ENG-SF22013-R1-FDR.pdf Markup Summary

Reference PCD project No CDR-20-004 -
<https://epcdevplanreview.com/Public/ProjectDetails/152502>

EXISTING DRAINAGE MAP HOMESTEAD NORTH

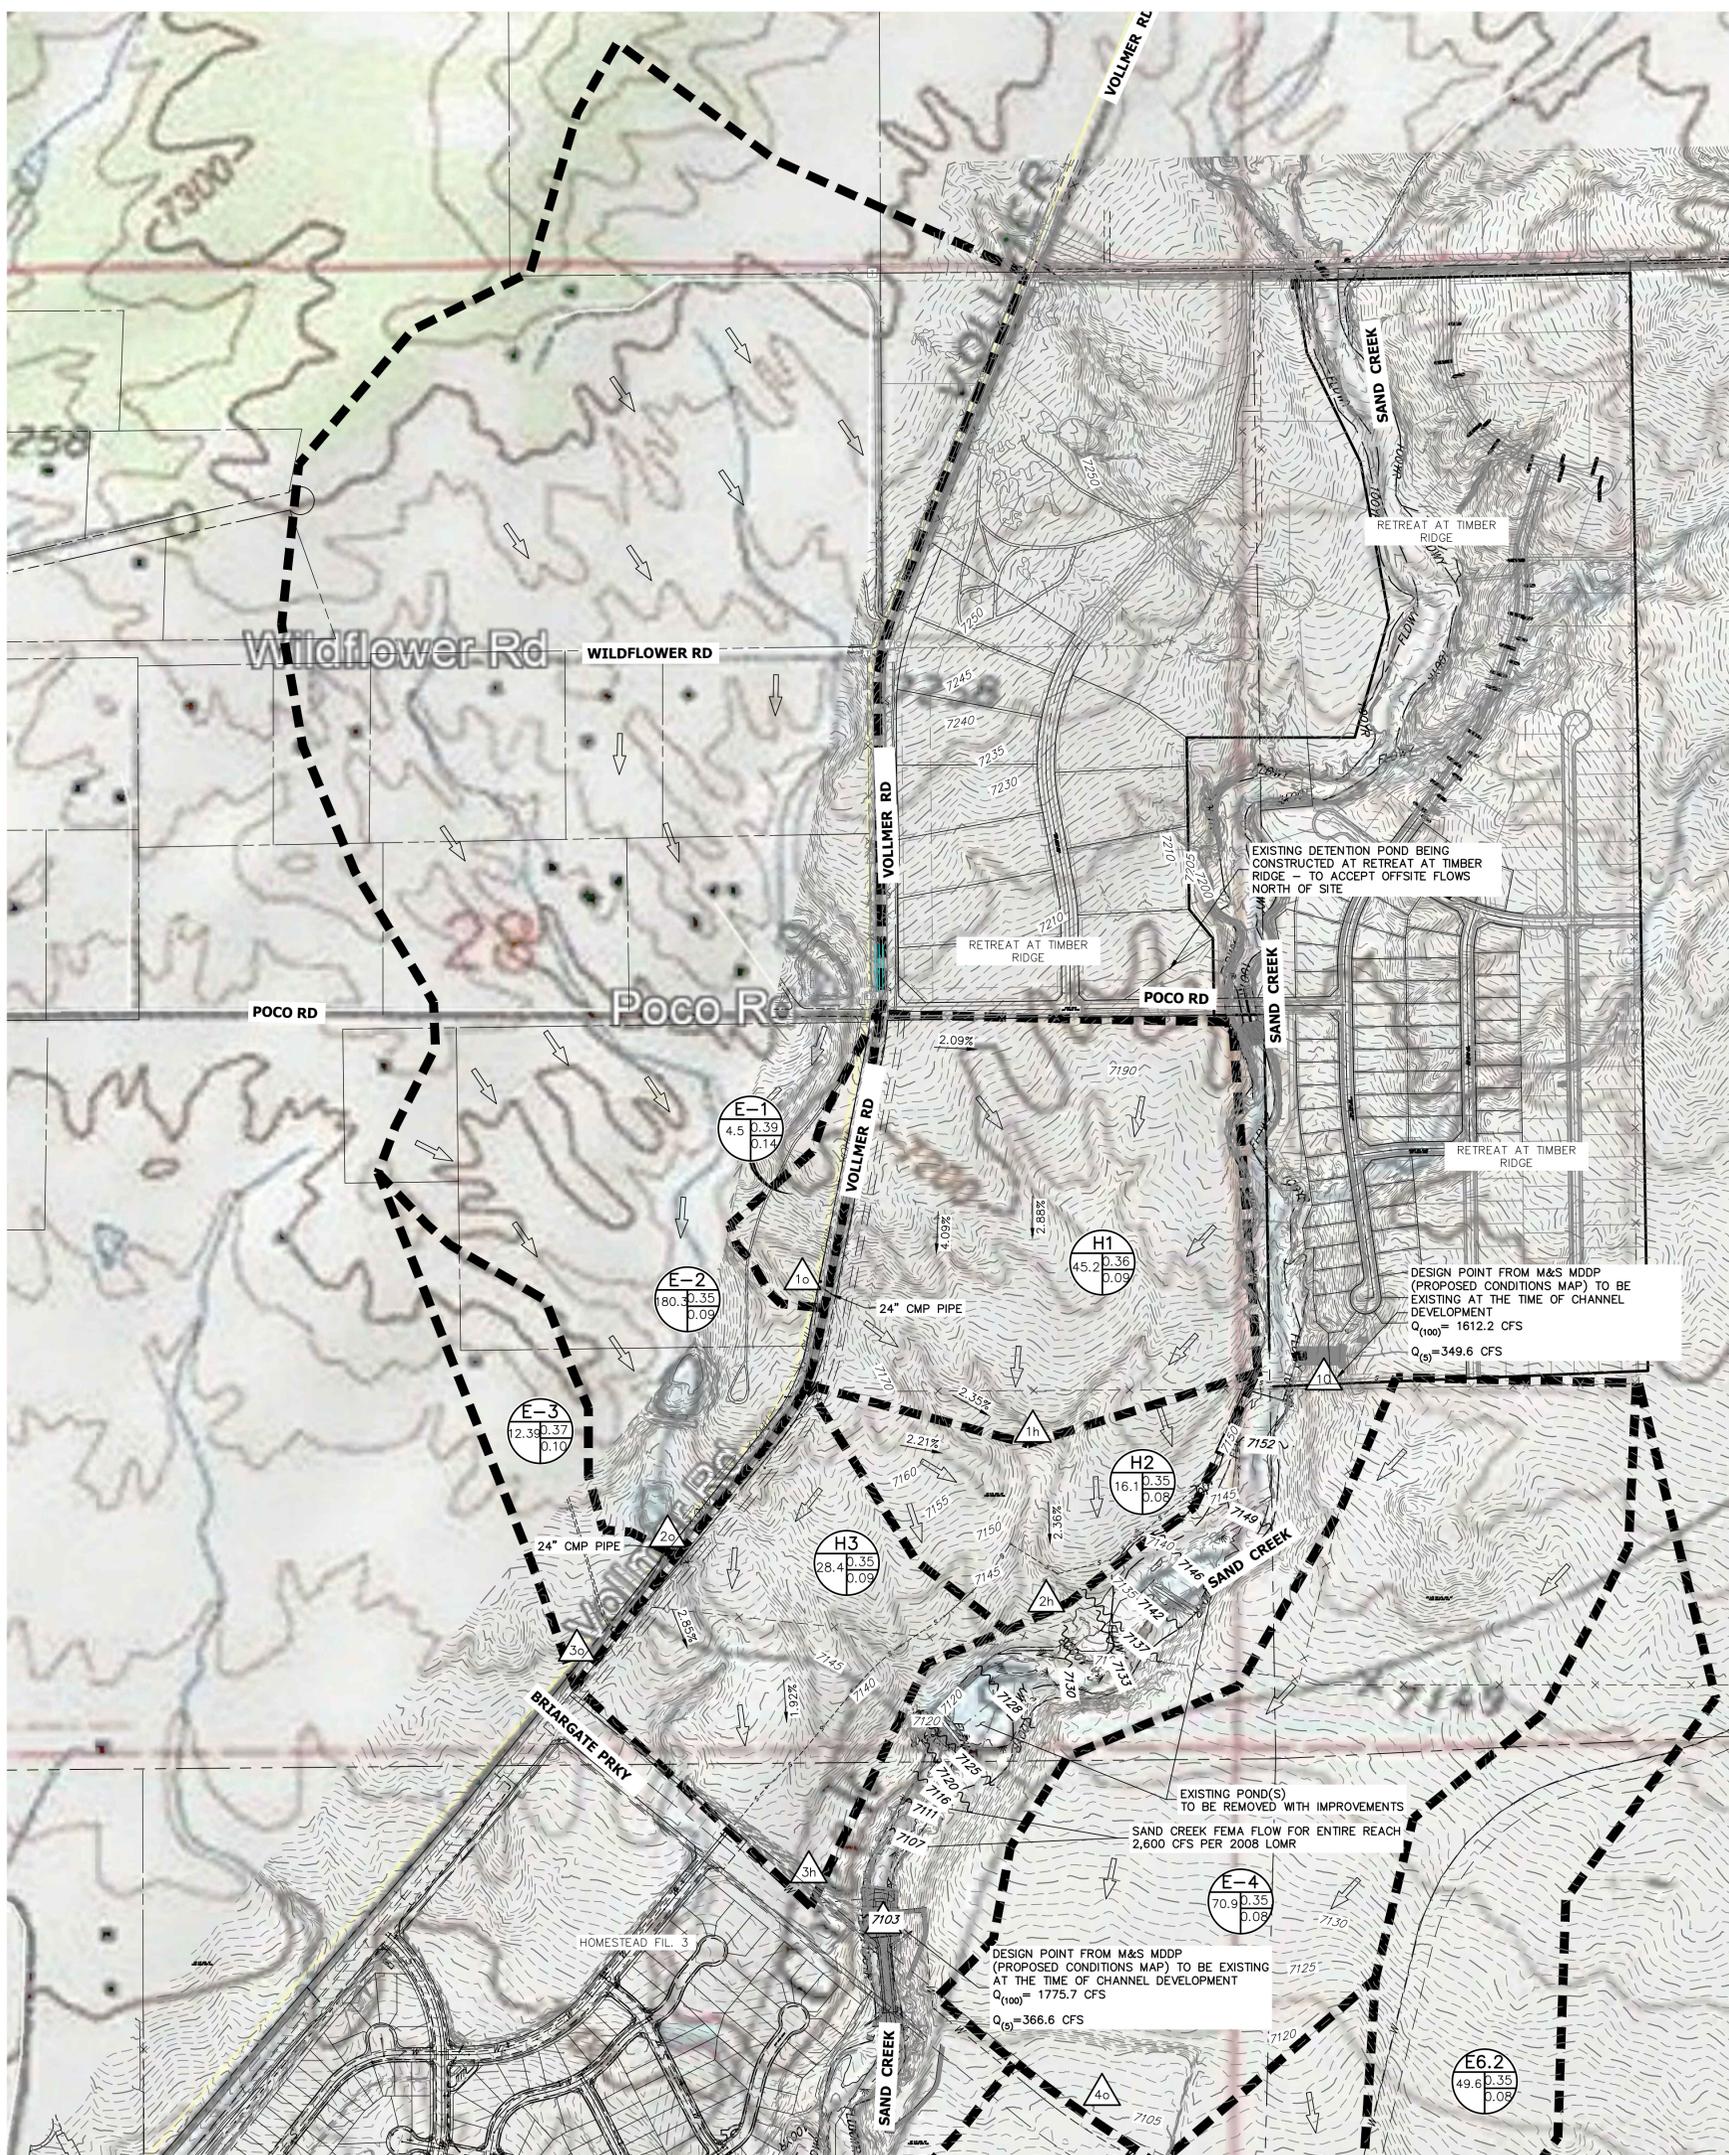
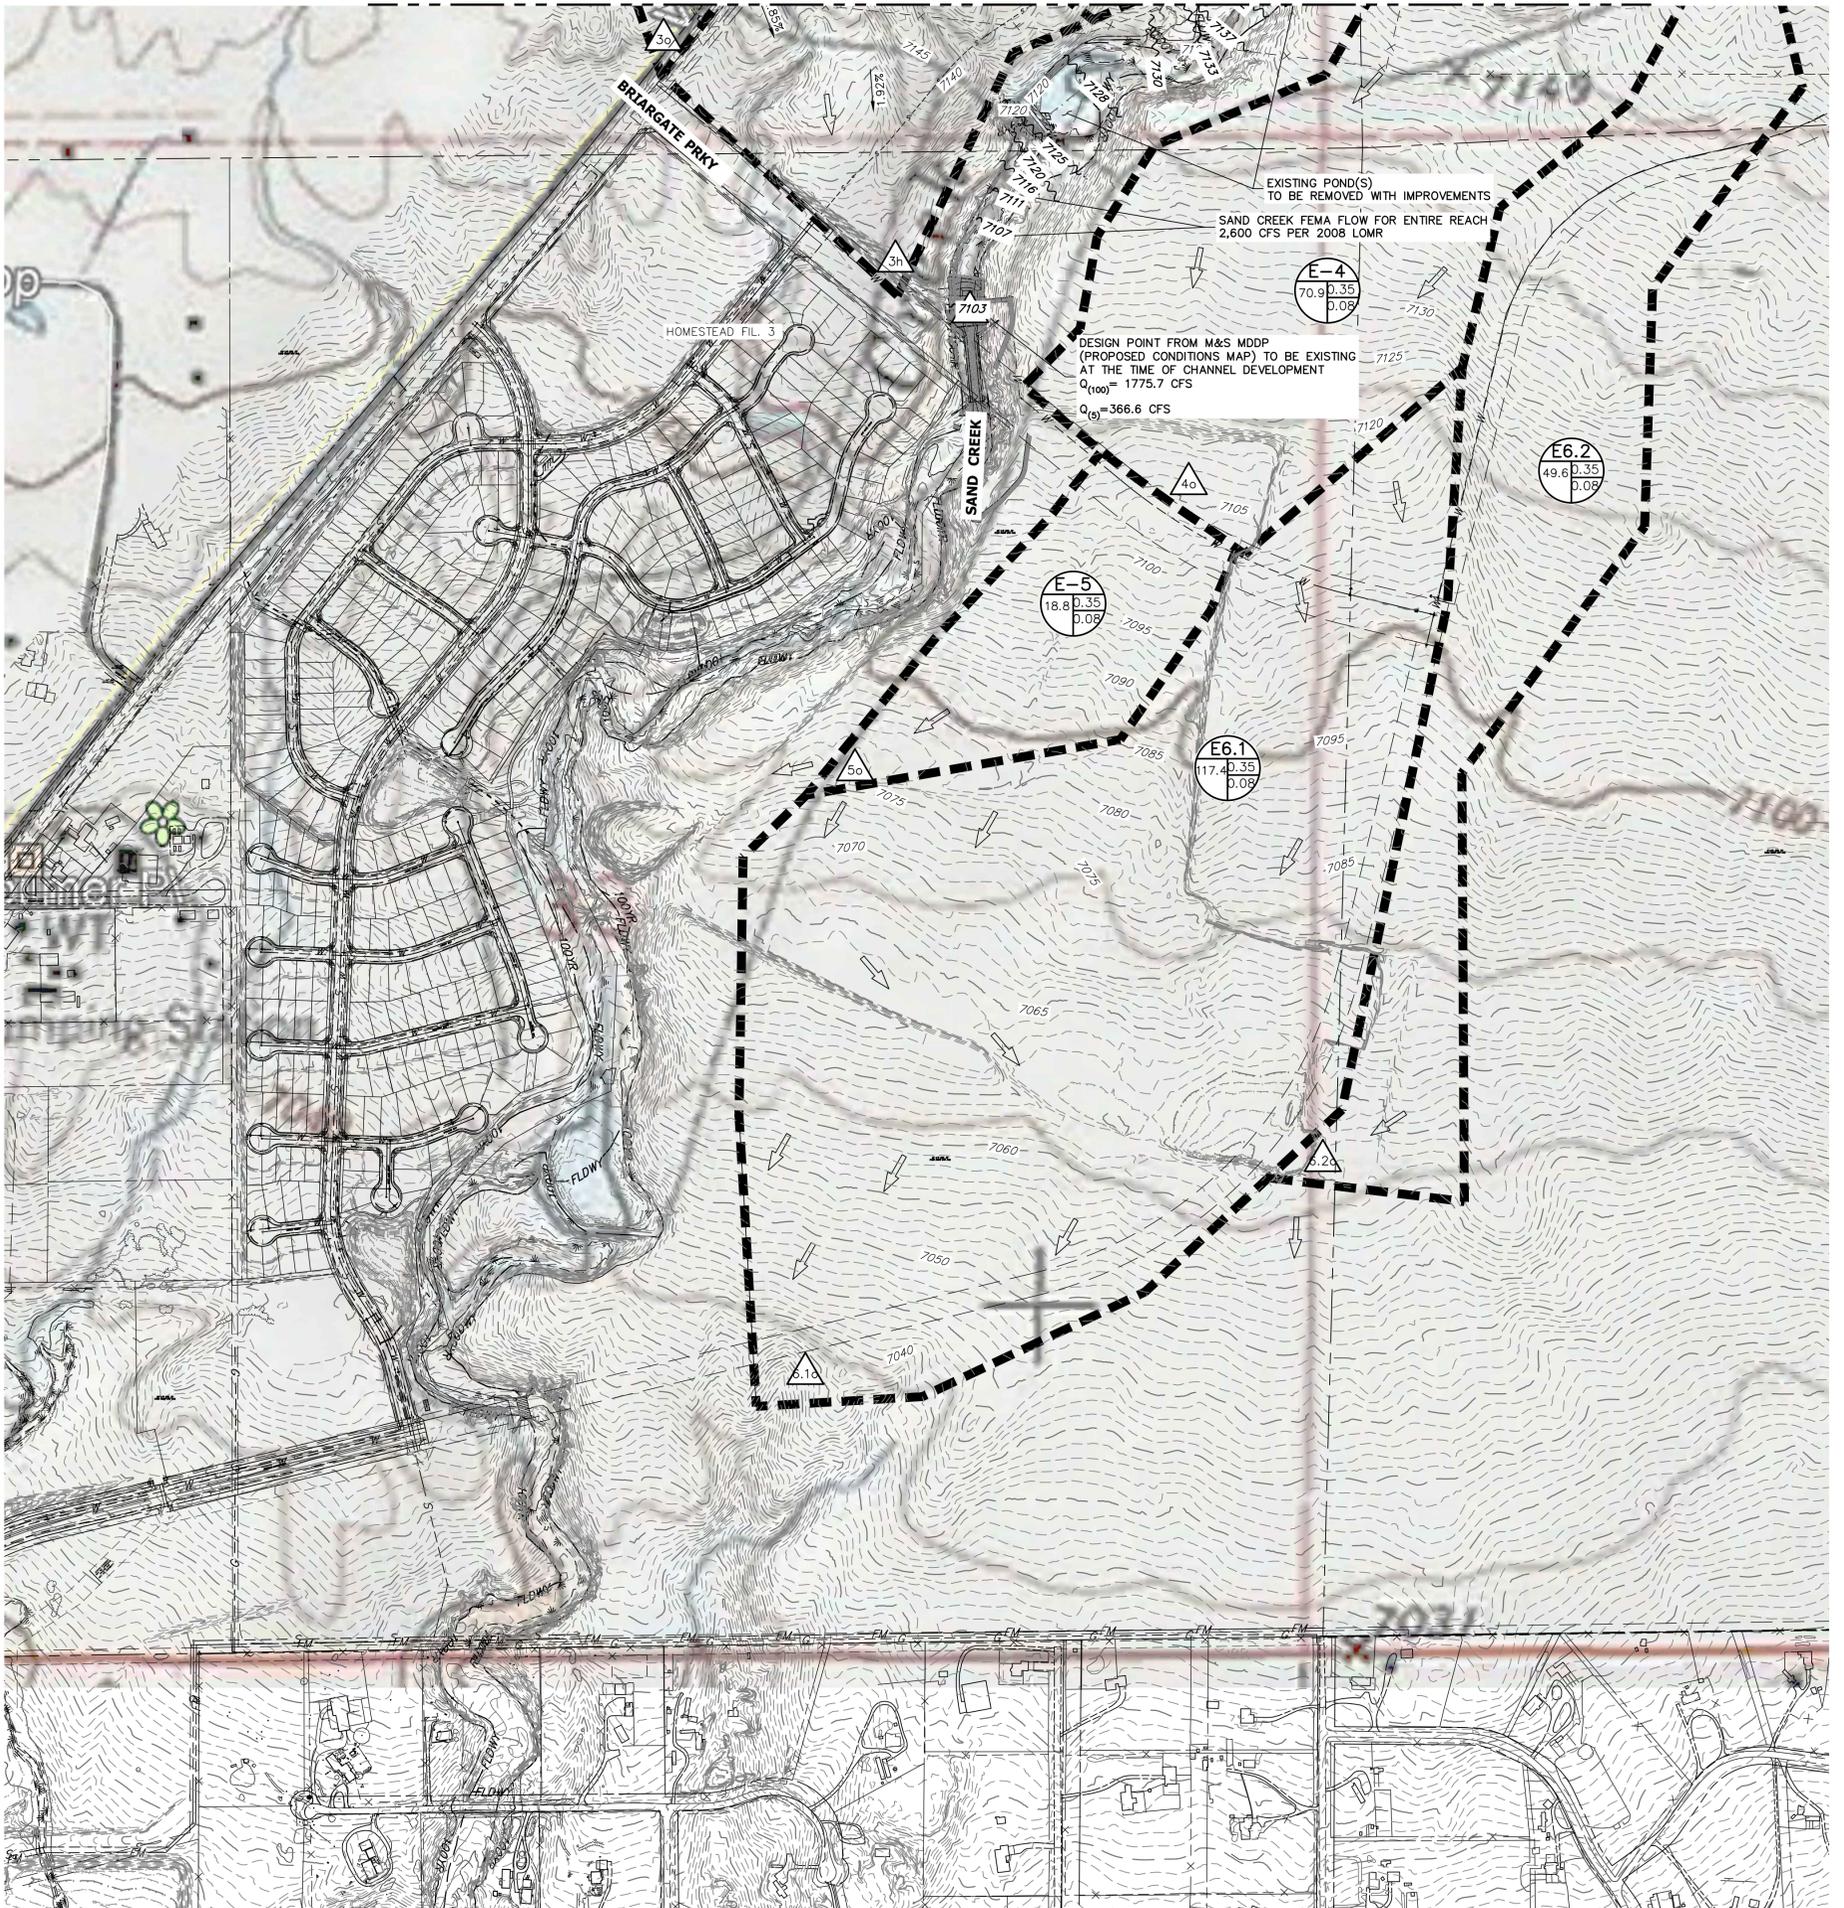
highlighted values
don't match
drainage plan

DRAINAGE MAP

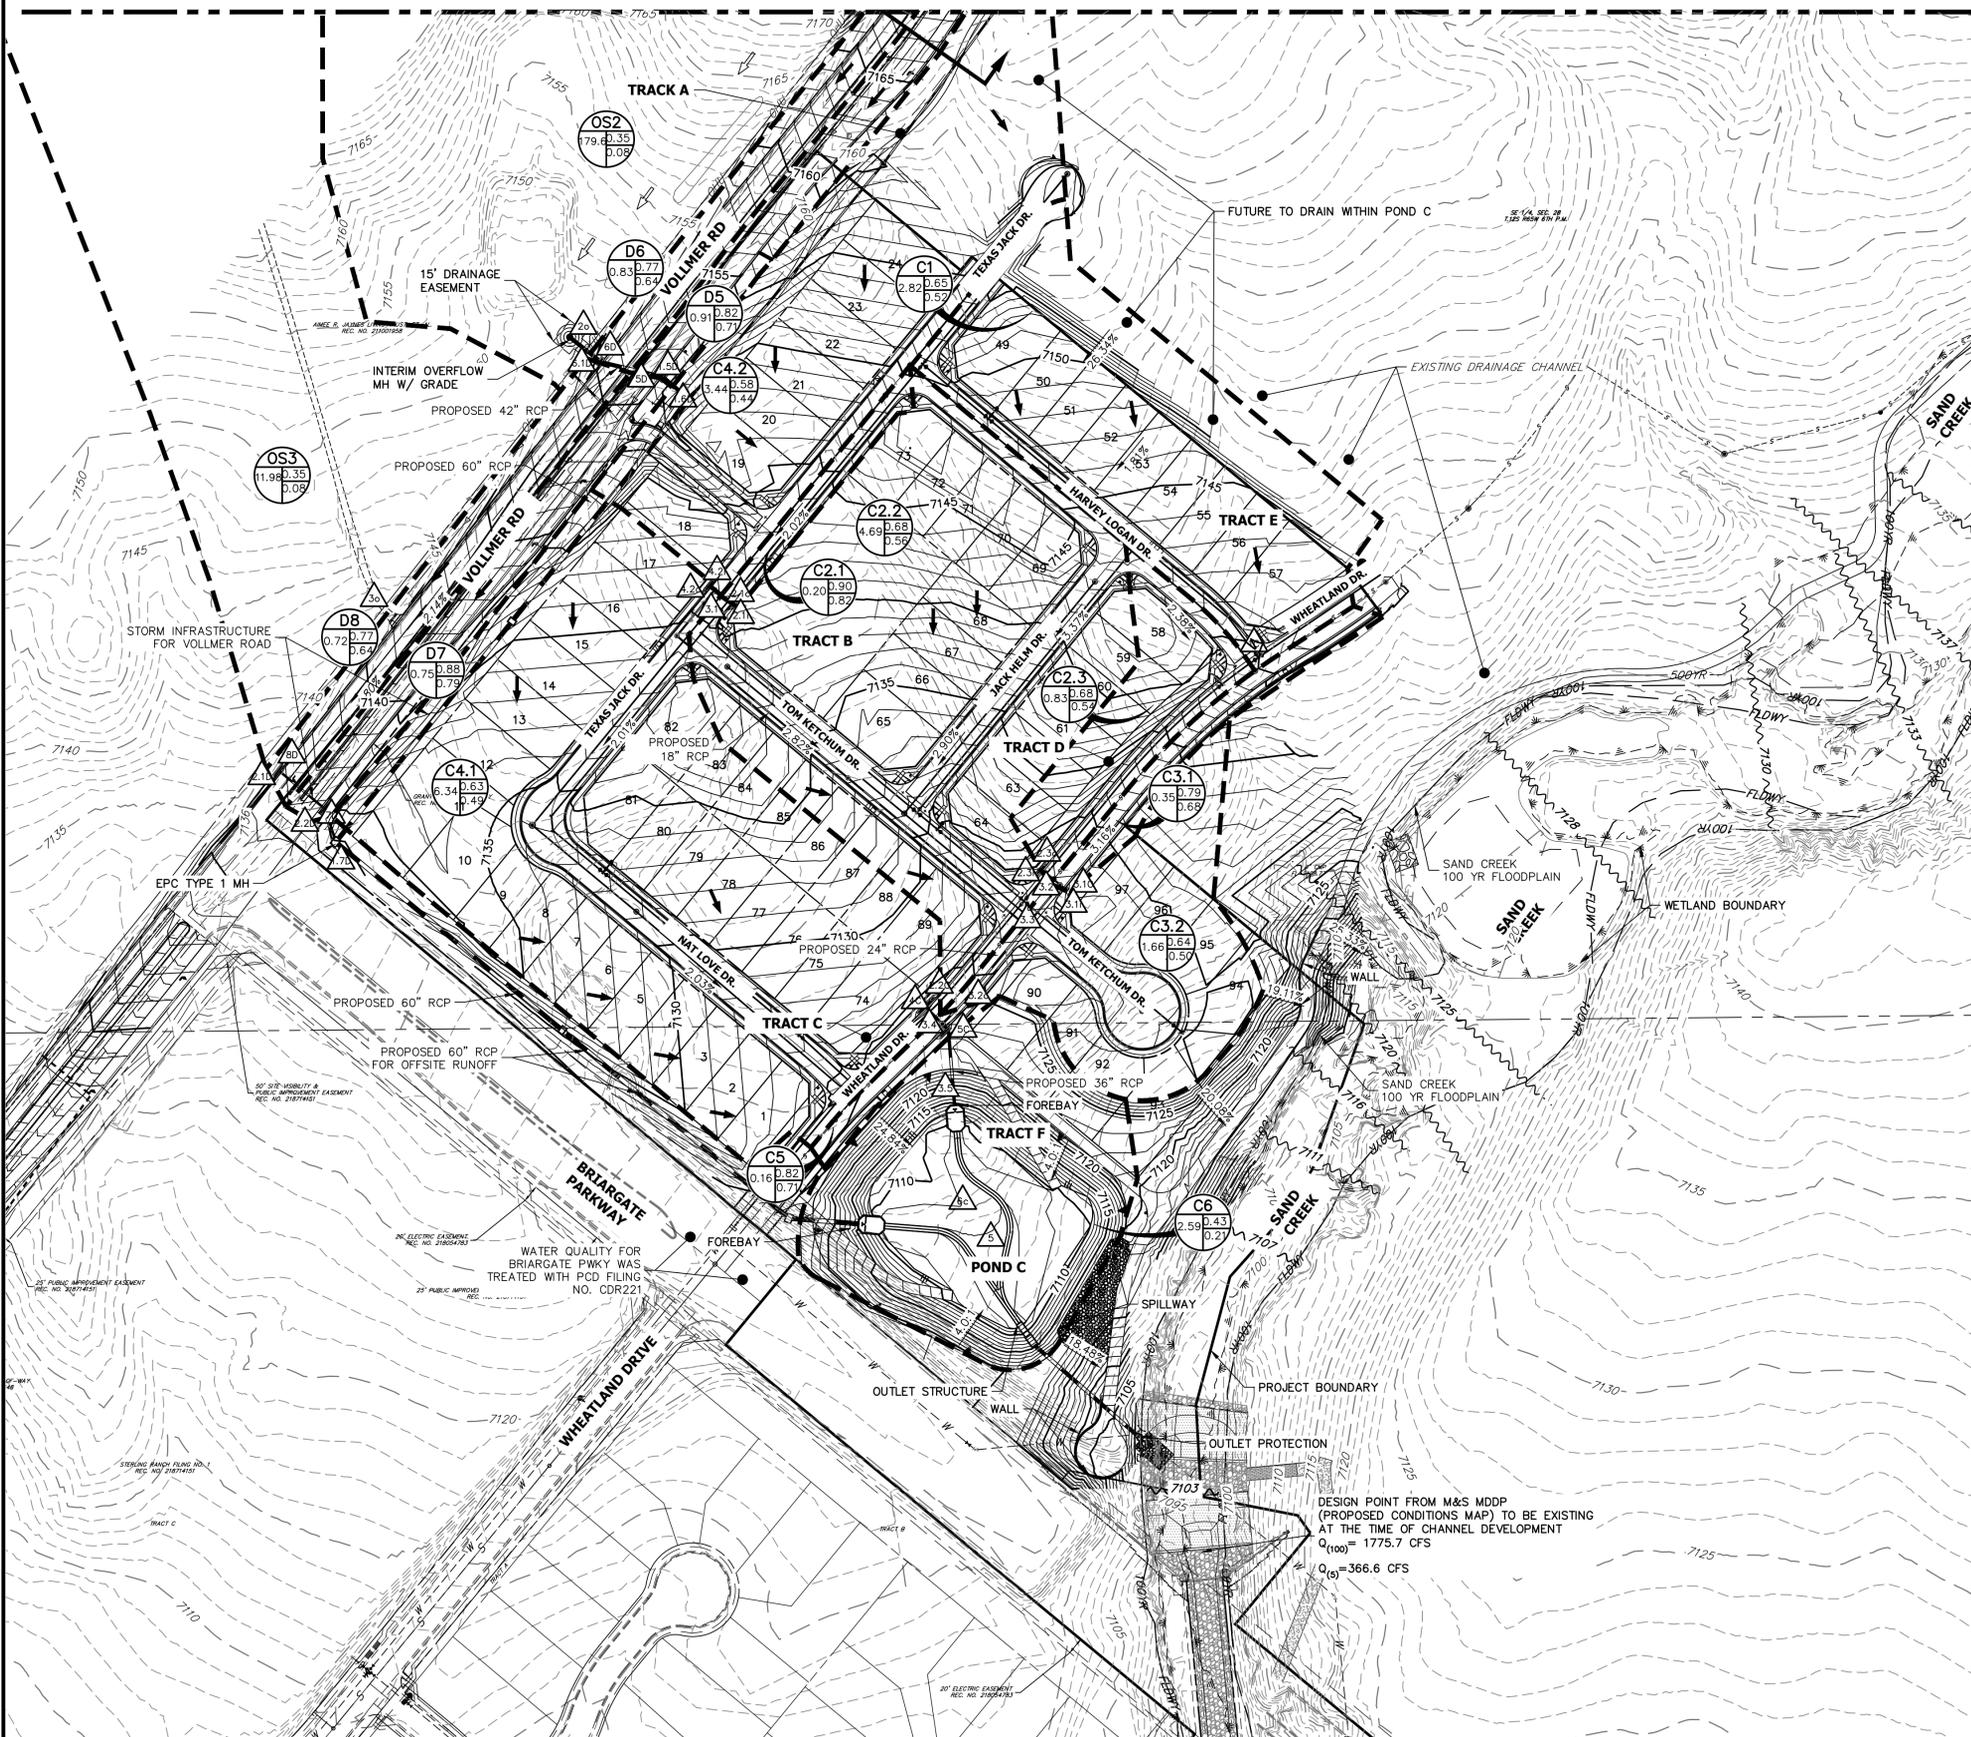
Provide design points? Show all flow paths.

Don't show future lots and roads

show right turn lane?

Provide road cross-sections

Label end of curb and gutter

Why is this off-map area of Briargate Pkwy shown on the GEC Plans but not on FDR or CD's? If nothing else, somewhere in this FDR (in text above and/or on this map) referenced that the drainage for Briargate Pkwy is analyzed with CDR221

Is a culvert needed under the trail?

label slopes

Don't show future lots and roads

extend the FEMA floodplain elevations to the matching contours

Add a table with inlet sizes at specified design points or add to this table or label the inlets on the plan

Show and label manhole

Grading doesn't look right. Provide sidewalk bench. See CD redlines.

Does any flow from Briargate go in here?
